CITY OF ALBUQUERQUE

June 3, 2022

Re: Odacrem Coffee Shop
1108 Broadway Blvd. NE
Traffic Circulation Layout
Architect's Stamp 04-28-22 (J14-D200)

REVISION DATE
STATE OF NEW MEXICO RICHARD P. BENNETT No. 1240 4/28/22 REGISTERED ARCHITECT
RBA ARCHITECTURE PC PLANNING DESIGN 1108 Broadway Blvd NE Albuquerque, NM 87102 www.rbaarch.com
DATE 04-28-2022
SHEET NUMBER AS-1.0

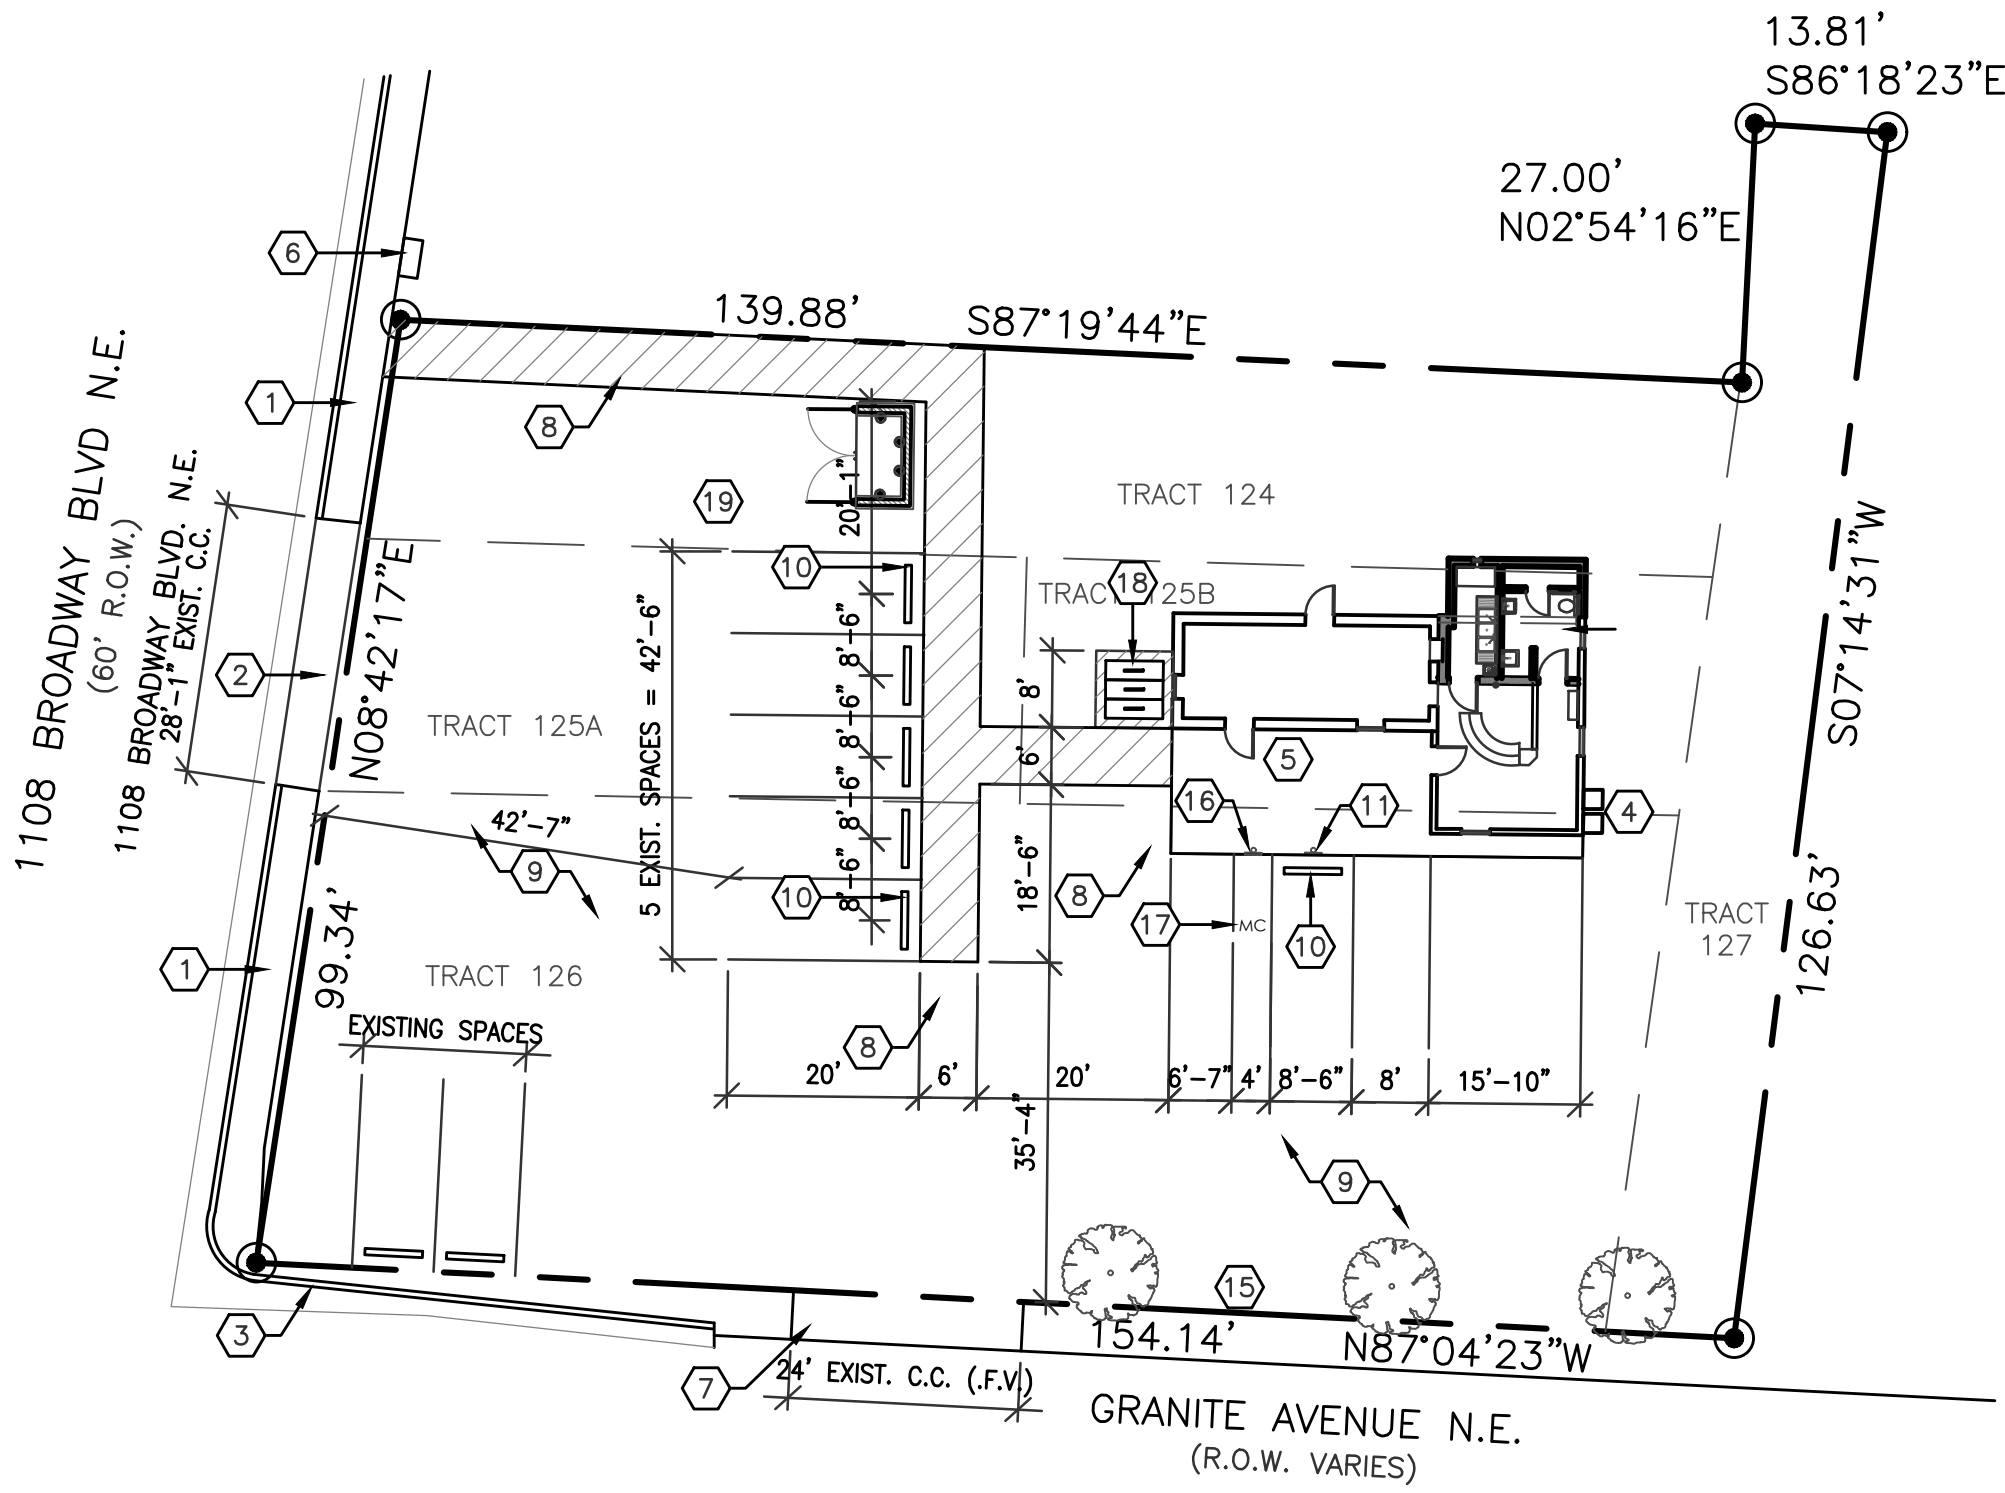
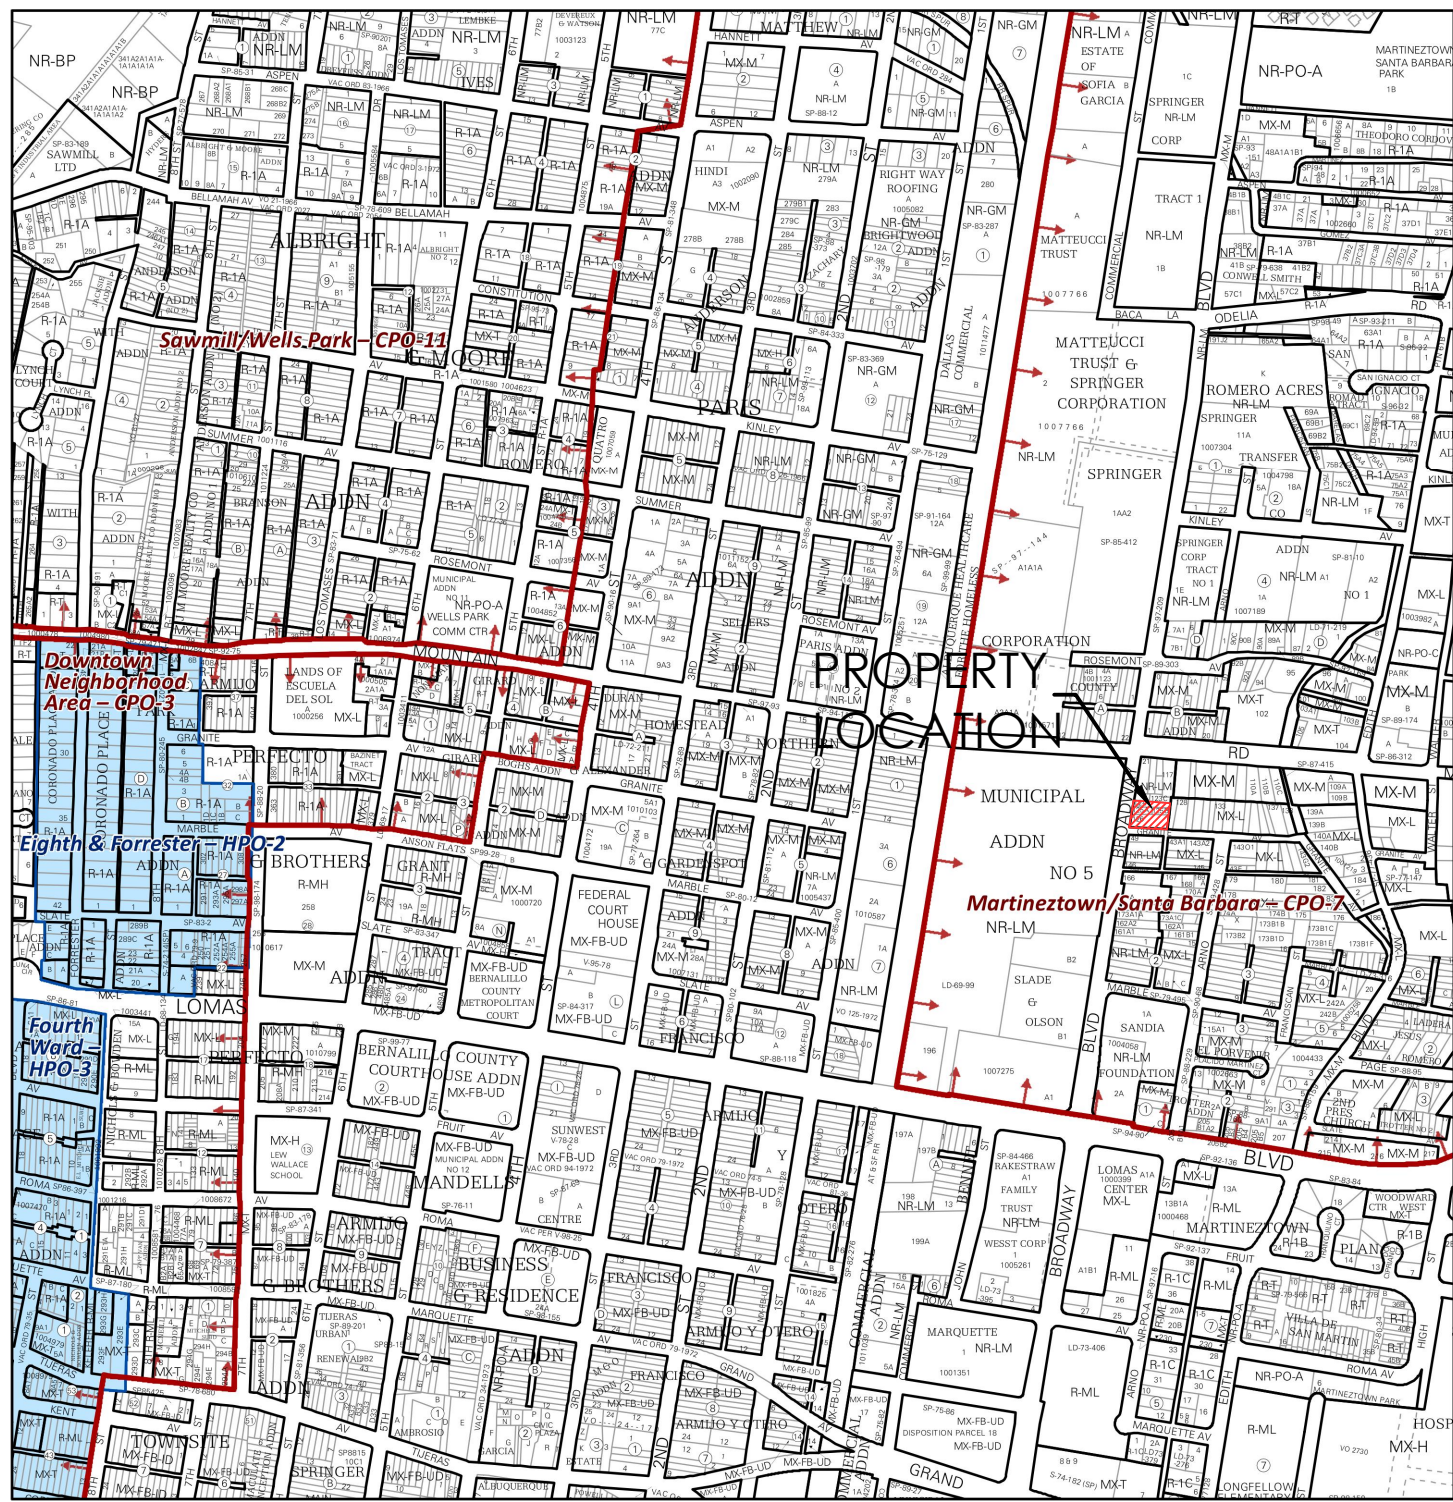
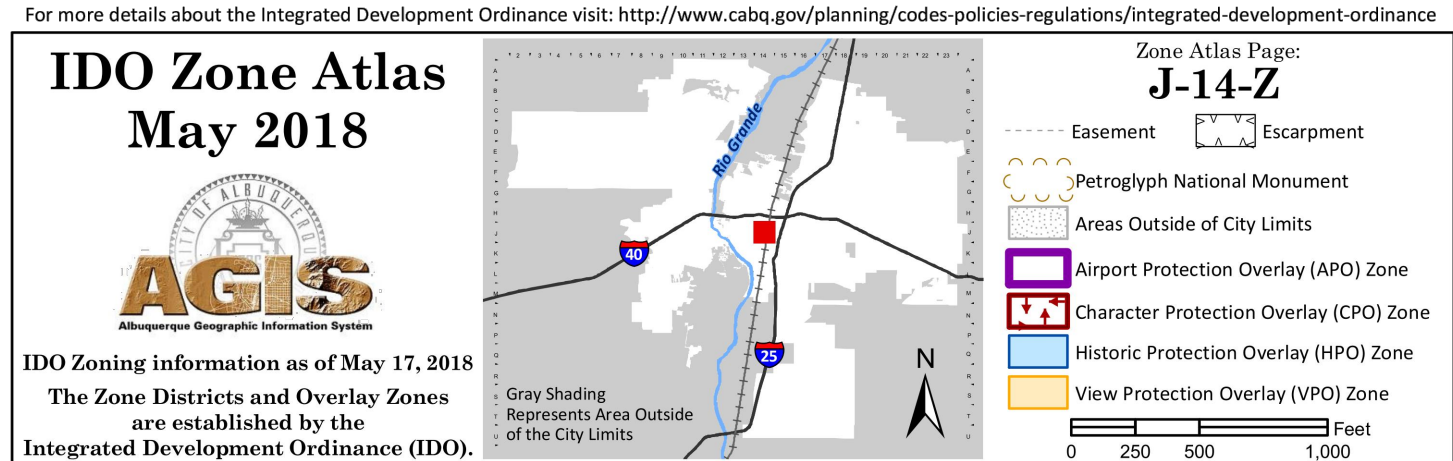
1. List the number of Bicycle parking spaces required by the IDO.
2. Please define the property line. GIS shows different lot lines, please verify.
3. Provide access easement with Tract 127, Tract 124, 125A, AND 126.

4. Granite Ave. Frontage:
 - Provide sidewalk per COA std dwg 2430 and curb and gutter per COA std dwg 2415.
 - For sidewalk waiver please contact Jeanne Wolfenbarger jwolfenbarger@cabq.gov (505-924-3991).

- Drivepad needs to build per city requirement, and should be ADA compatible.
5. Drivepad off Broadway needs to be modified to meet COA and ADA requirements.

6. The Ramp at the corner of Broadway and Granite is not ADA compatible. Please modify it. Also, a minimum 4 ft wide pedestrian path should be shown around the pole; show this dimension on the site plan to ensure that a minimum 4ft wide path is obtained.

7. Provide the dimensions for the existing parking spaces.
8. Please identify all existing buildings, doors, structures, sidewalks, curbs, drive pads, wall and anything that influences the parking and circulation on the site.

9. Identify the right of way width, medians, curb cuts, and street widths on Granite Ave. NE.
10. Please list the width and length for all existing and proposed parking spaces. Some dimensions are not shown.

11. The minimum parking stall dimensions are:

Type of parking	Min. Width	Min. Length	Min. Overhang
Standard	8.5'	18'	2'
Compact	7.5'	15'	1.5'

Motorcycle	4'	8'	N/A
ADA	8.5'	18'	2'

12. ADA parking spaces should be concrete or pavement.
13. The ADA accessible spaces must include an access aisle. Van accessible aisles should be 8ft wide; all others should be 5ft wide.

14. The ADA accessible parking sign must have the required language per 66-7-352.4C NMSA 1978 **"Violators Are Subject to a Fine and/or Towing."** Please call out detail and location of signs.

15. The ADA access aisles shall have the words **"NO PARKING"** in capital letters, each of which shall be at least one foot high and at least two inches wide, placed at the rear of the parking space so as to be close to where an adjacent vehicle's rear tire would be placed. (66-1-4.1.B NMSA 1978)

16. ADA curb ramps must be updated to current standards and have truncated domes installed.
17. Provide ADA and Motorcycle face sign details.
18. Show all drive aisle widths and radii. Some dimensions are not shown.

19. The minimum drive aisle dimensions are shown below

Minimum Drive Aisle Width
Two Way Traffic	22'
Main Circulation Road	24'
Fire Lane	20'

20. Per the IDO, a 6 ft. wide ADA accessible pedestrian pathway is required from the public sidewalk to the building entrances. Please clearly show this pathway and provide details.
21. Per DPM, a 6 ft. wide ADA accessible pedestrian pathway is required from the ADA parking stall access aisles to the building entrances. Please clearly show this pathway and provide details.
22. ADA accessible pedestrian pathway should not be placed behind parking space or adjacent to a vehicular way. Vehicle and pedestrian/wheel chair conflicts should be avoided as much as possible.
23. Refuse vehicle maneuvering shall be contained on-site. The refuse vehicle shall not back into the public right of way. provide a copy of refuse approval.
24. A hard driving surface will be required for the ADA parking spaces.
25. Please provide a sight distance exhibit

26. Show the clear Intersection Distance sight triangle for Broadway Blvd. and add the following note to the plan: "Landscaping and signage will not interfere with clear sight requirements. Therefore, signs, walls, trees, and shrubbery between 3 and 8 feet tall (as measured from the gutter pan) will not be acceptable in the clear sight triangle.

27. Show the clear sight triangle for Granite Ave. and add the following note to the plan: "Landscaping and signage will not interfere with clear sight requirements. Therefore, signs, walls, trees, and shrubbery between 3 and 8 feet tall (as measured from the gutter pan) will not be acceptable in the clear sight triangle.

28. Please specify the City Standard Drawing Number when applicable.
29. Shared Site access: driveways that straddle property lines, or are entirely on one property but are to be used by another property, shall have an access easement. Please include a copy of your shared access agreement with the adjacent property owner.
